ASPECT Studios

25 November 2020

Harbourside Shopping Centre Redevelopment DA (SSD-7874) – Response to Submissions

1 Section 1
1:350

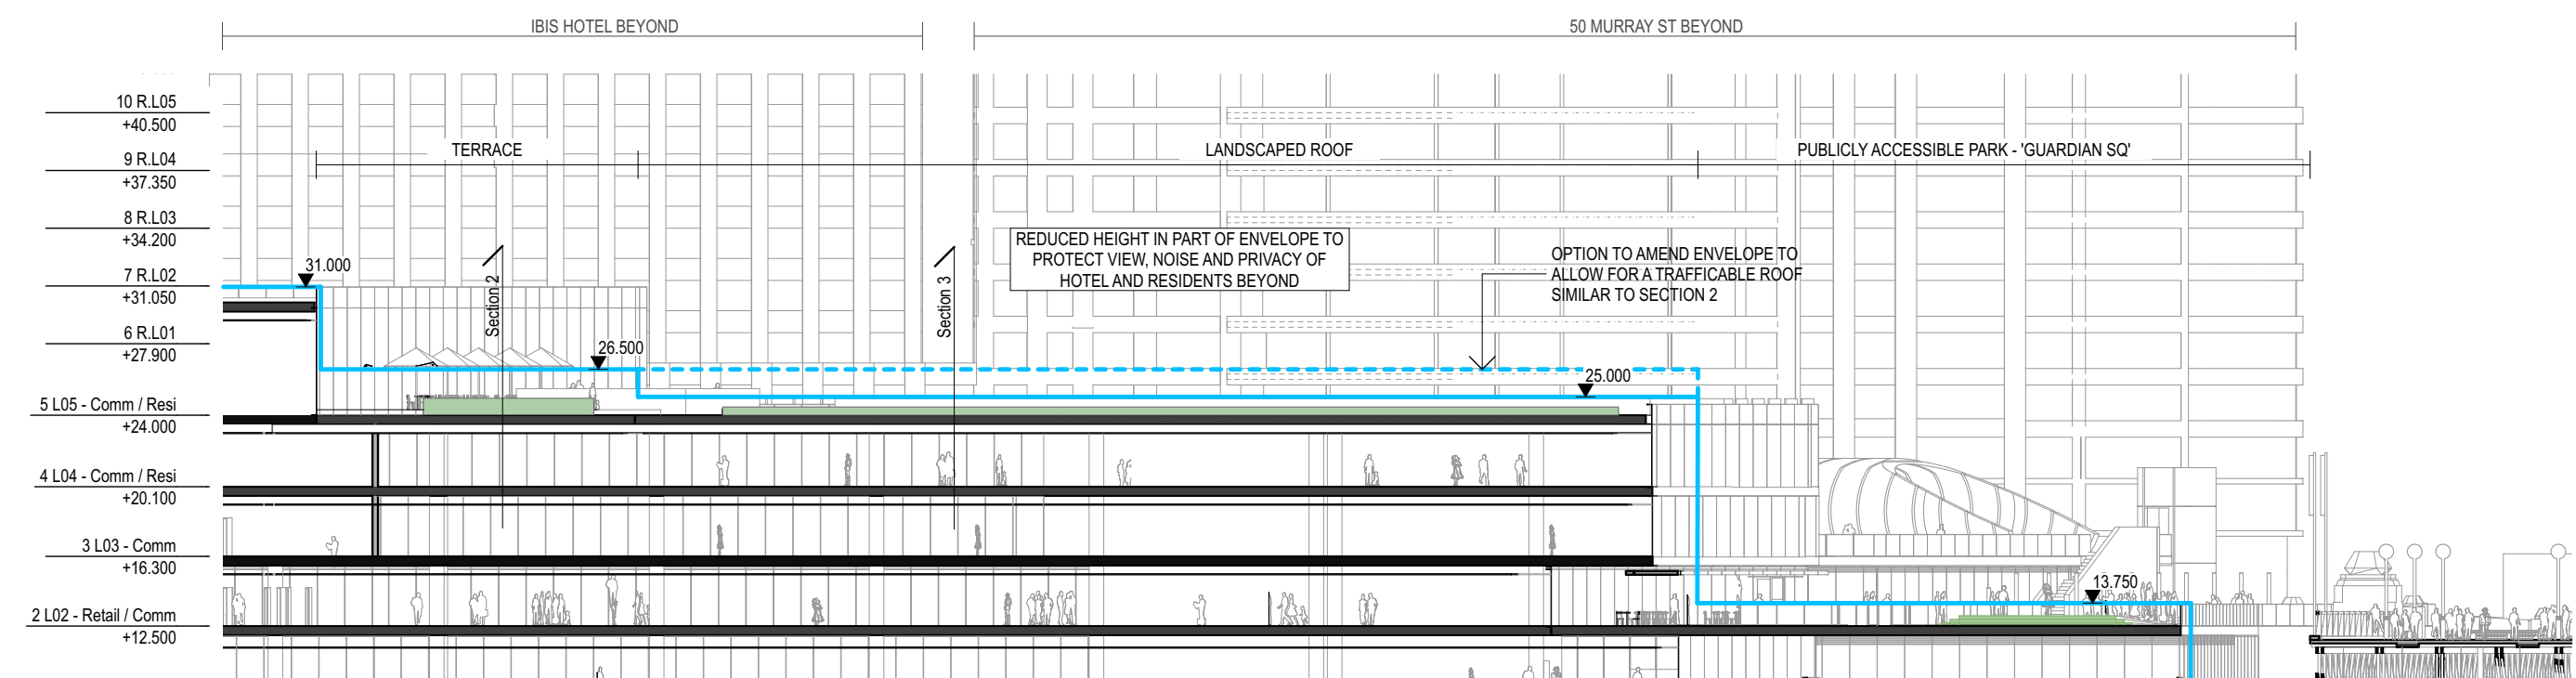
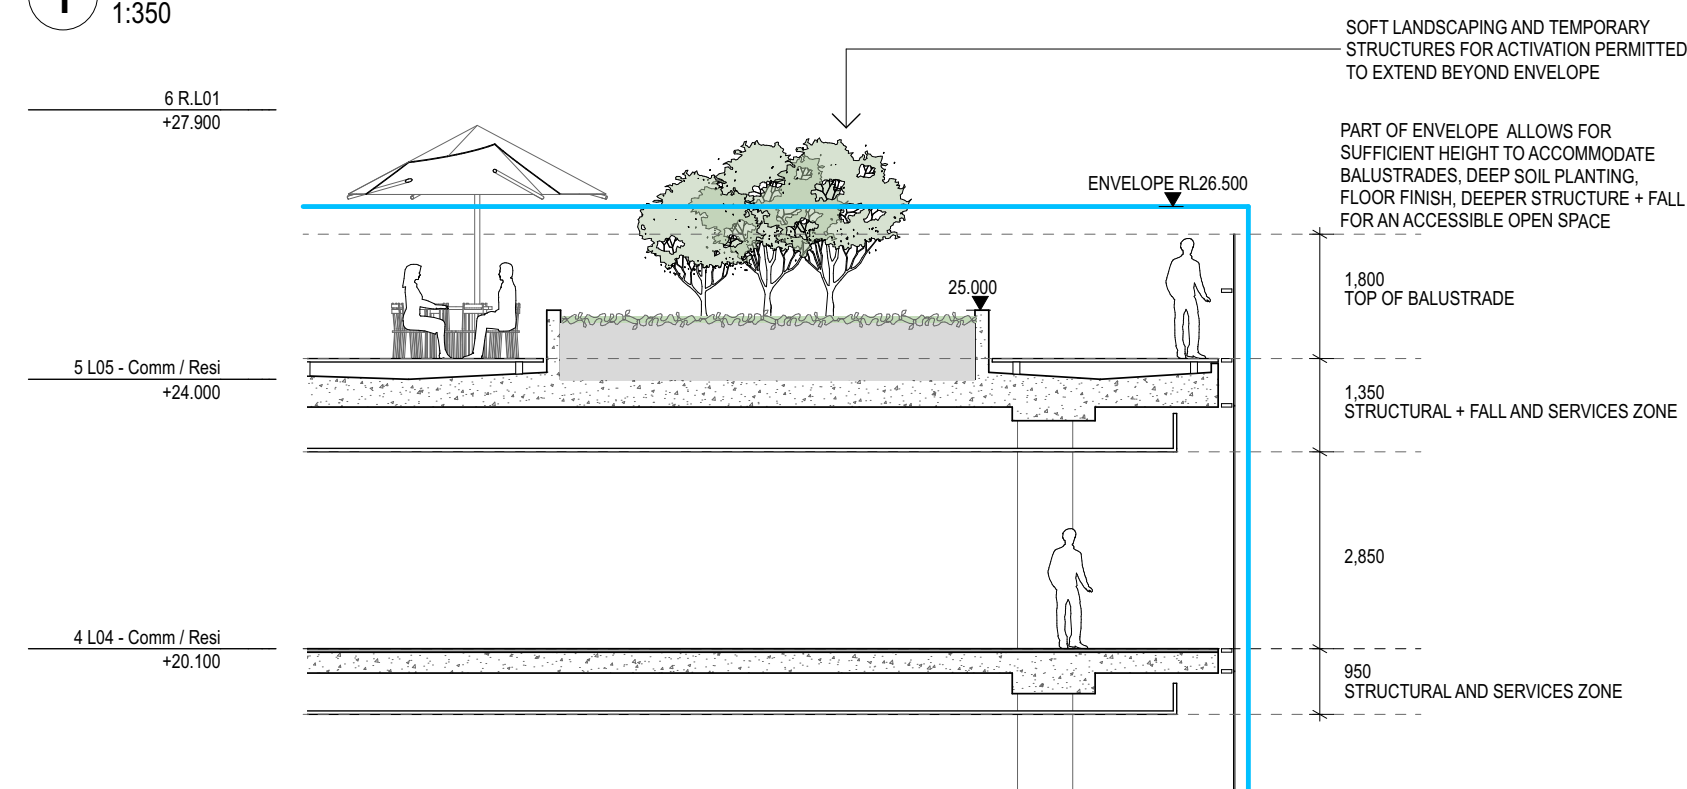
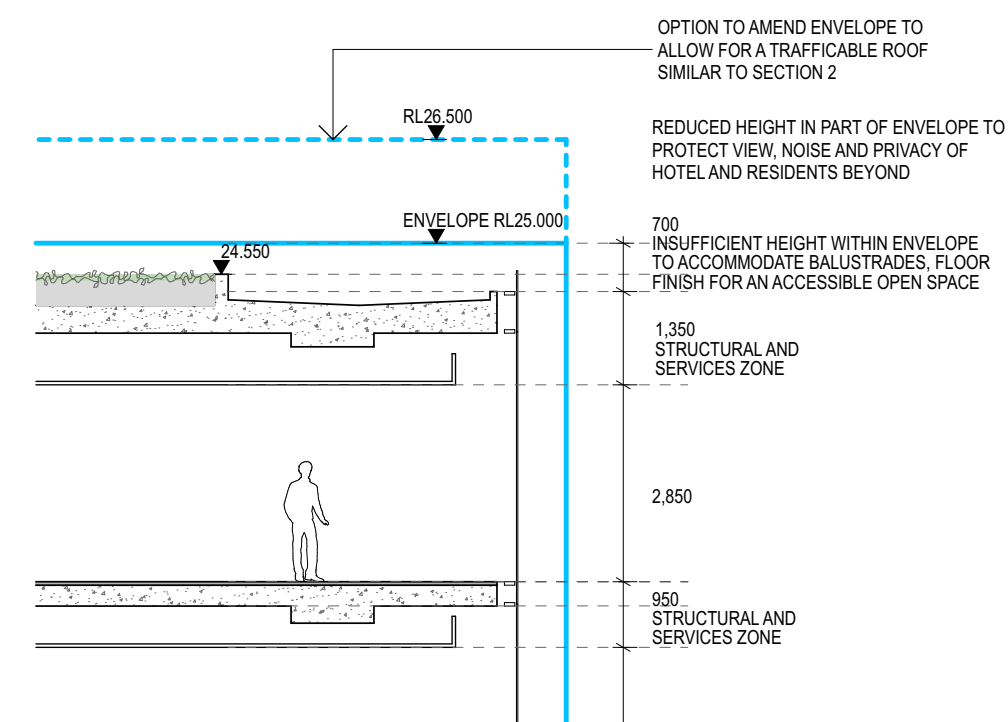
The accompanying Public Domain Report, prepared by Aspects Studio, states that the inaccessible roof areas must remain so because of the strict building envelope constraints. It is also indicated that no trees are proposed on the green roofs as they would interrupt the sight lines and harbour views from the apartments behind. The City has significant canopy cover targets, and the proposed green roofs are extensive in area. To not plant trees in this space, even in select, scattered groups, is a missed opportunity.

The City reiterates that soil depths should vary between 450mm-1000mm across these roofs to support a diversity of planting and realise a valuable urban ecology within the CBD environment. Whilst it is acknowledged that providing accessible green roofs would have knock-on implications for shade structures and balustrades, it is reiterated that some of the inaccessible green roof should be made accessible and at the very least, to the northern roof. Should these roofs remain inaccessible, it should facilitate substantial biodiversity and habitat creation and should be developed in consultation with an ecologist. This should result in a much more biodiverse plant list as well as physical habitat features where appropriate.

In addition to the previous response regarding building envelope restrictions please also refer to **FJMT Architects SK201125 01 RTS - Podium L5 Detailed Section** through inaccessible green roof areas.

As shown in the section (refer to **FJMT Architects SK201125 01 RTS - Podium L5 Detailed Section**) through inaccessible green roof areas, soil depths of 450-1000mm are not achievable due to structural slab levels or to have trees on the roof due to strict level restrictions associated with the building envelope. Please **see blue line indicated in FJMT Architects section** .
